# CITY OF ALBUQUERQUE

**Re: Nusenda Credit Union**  
**2801 Juan Tabo Blvd. NE**  
**Traffic Circulation Layout**  
Architect's Stamp 07-06-22 (H21-D020)

Based upon the information provided in your submittal received 07-07-22, the above referenced plan cannot be approved for Building Permit until the following comments are addressed:

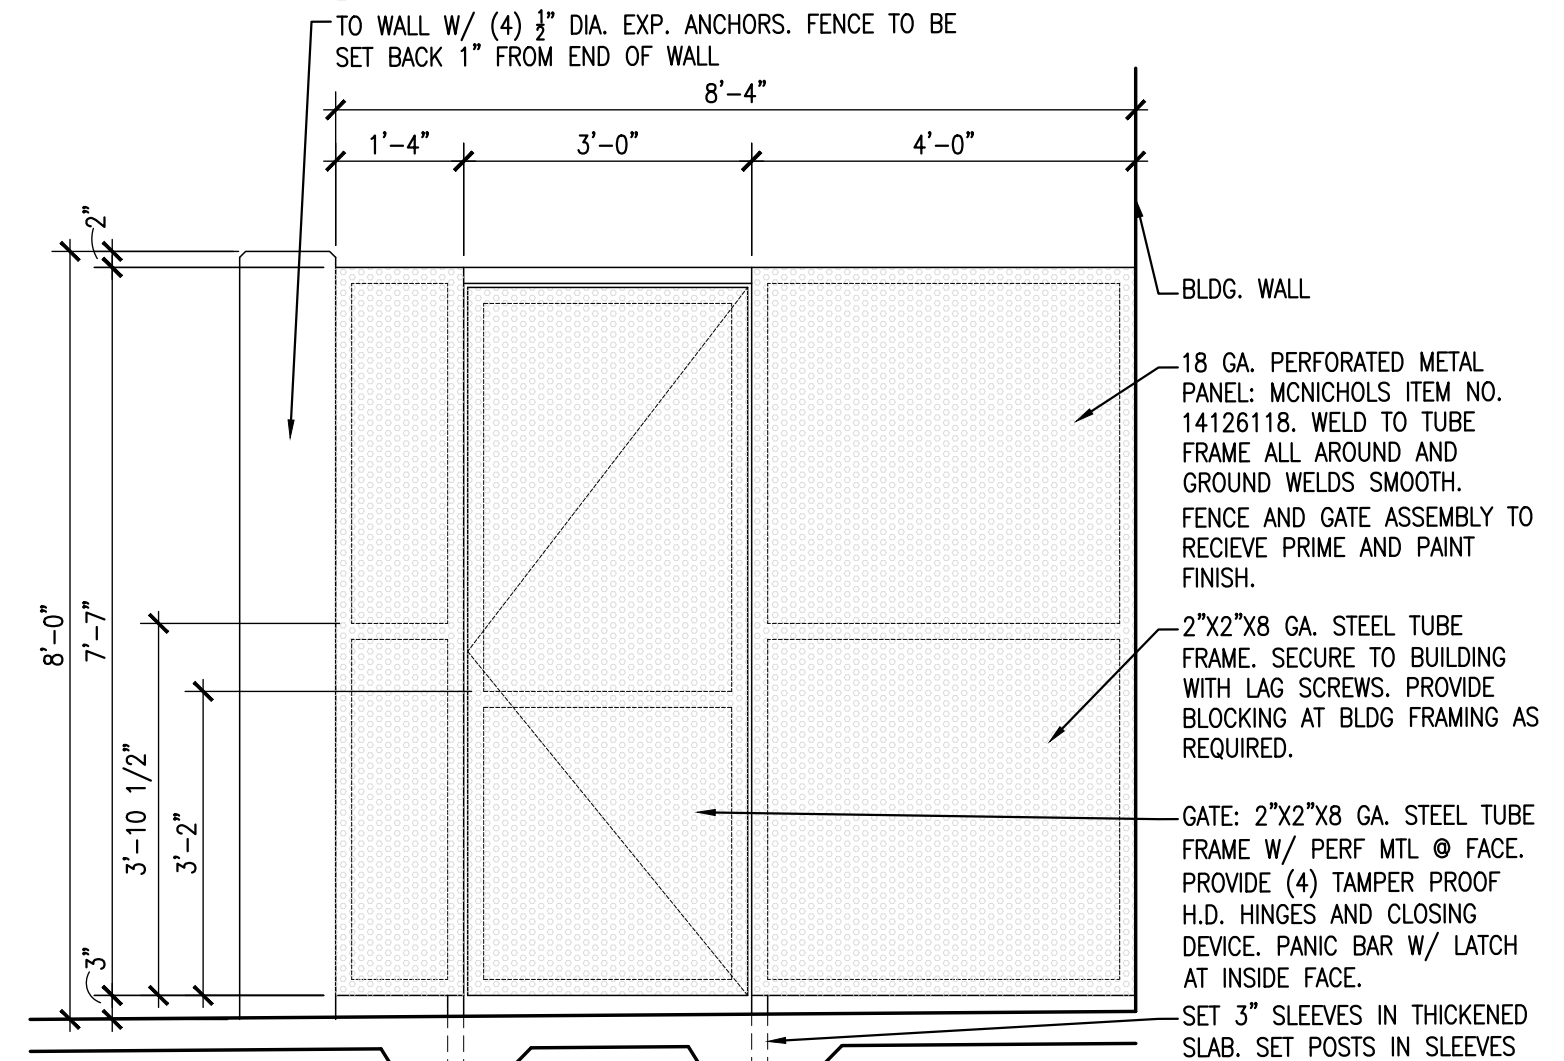
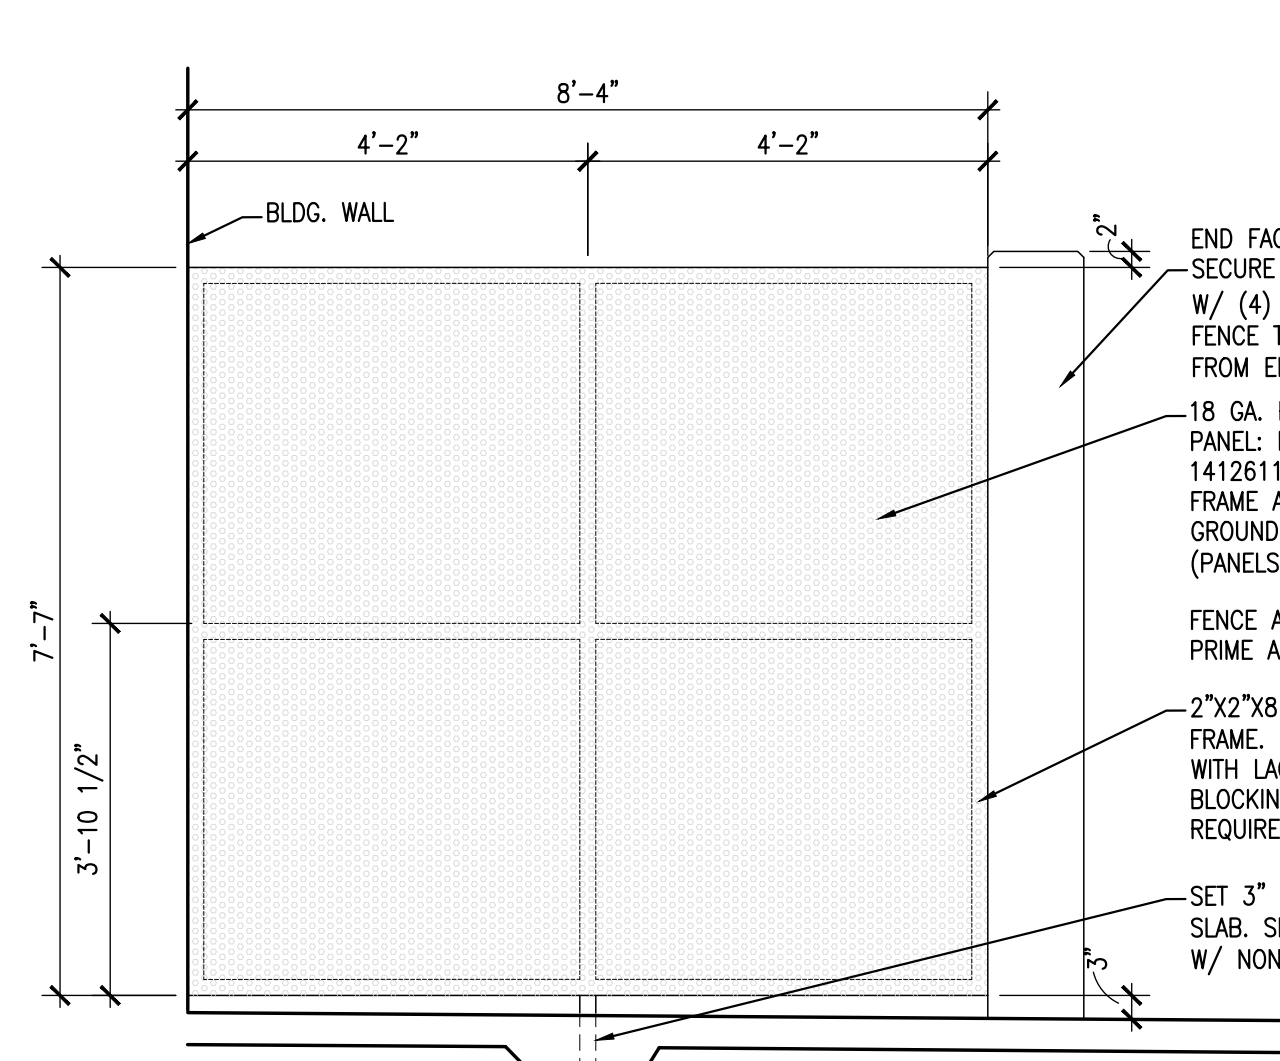
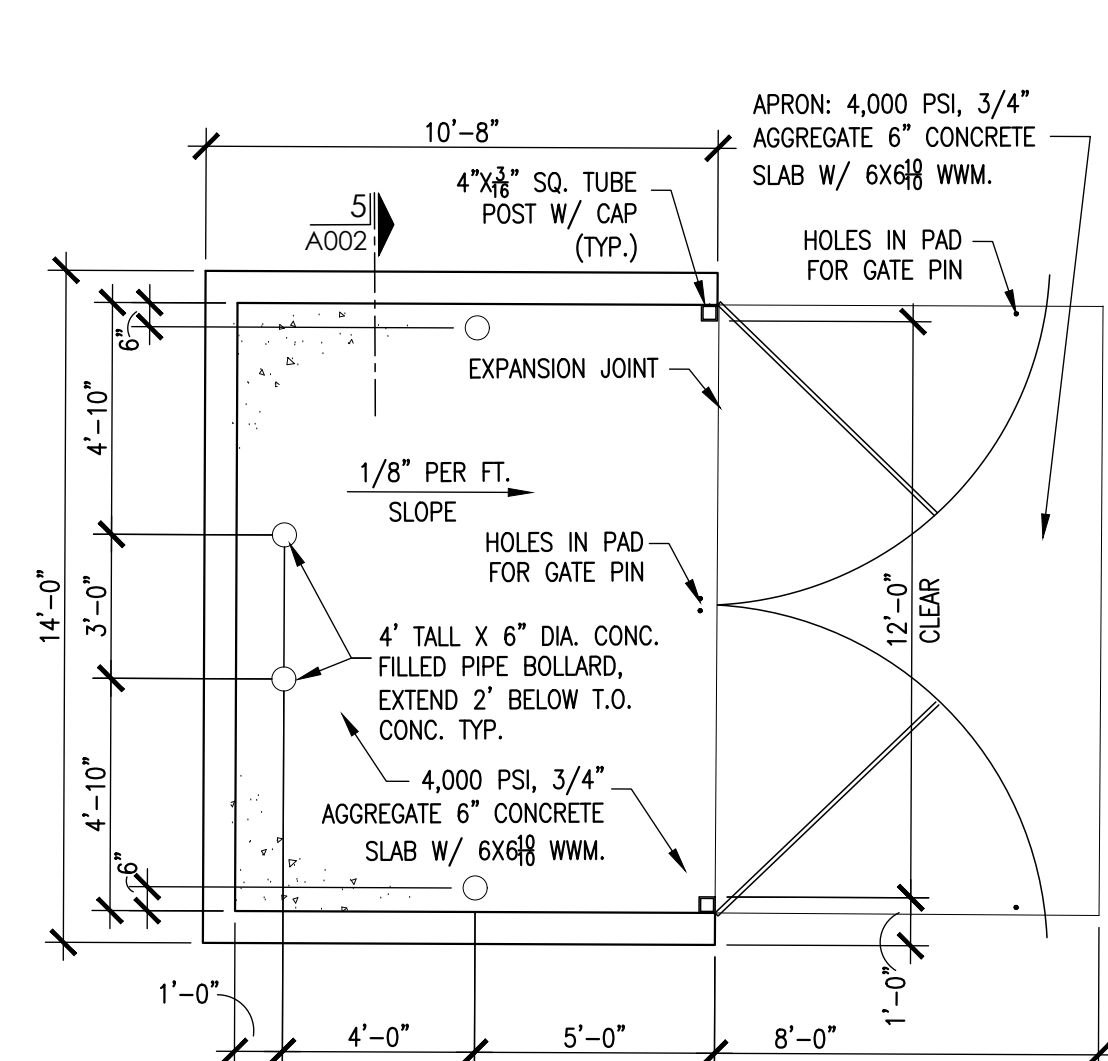
5. Sheet A002 is missing.
6. Keynote 1: reference COA std dwg 2430.
7. The ADA accessible parking sign must have the required language per 66-7-352.4C NMSA 1978 **"Violators Are Subject to a Fine and/or Towing."** Please call out detail and location of signs.

8. All bicycle racks shall be designed according to the following guidelines:
  - a. The rack shall be a minimum 30 inches tall and 18 inches wide.
  - b. The bicycle frame shall be supported horizontally at two or more places. Comb/toaster racks are not allowed.

9. Bicycle racks shall be sturdy and anchored to a concrete pad.
10. A 1-foot clear zone around the bicycle parking stall shall be provided.
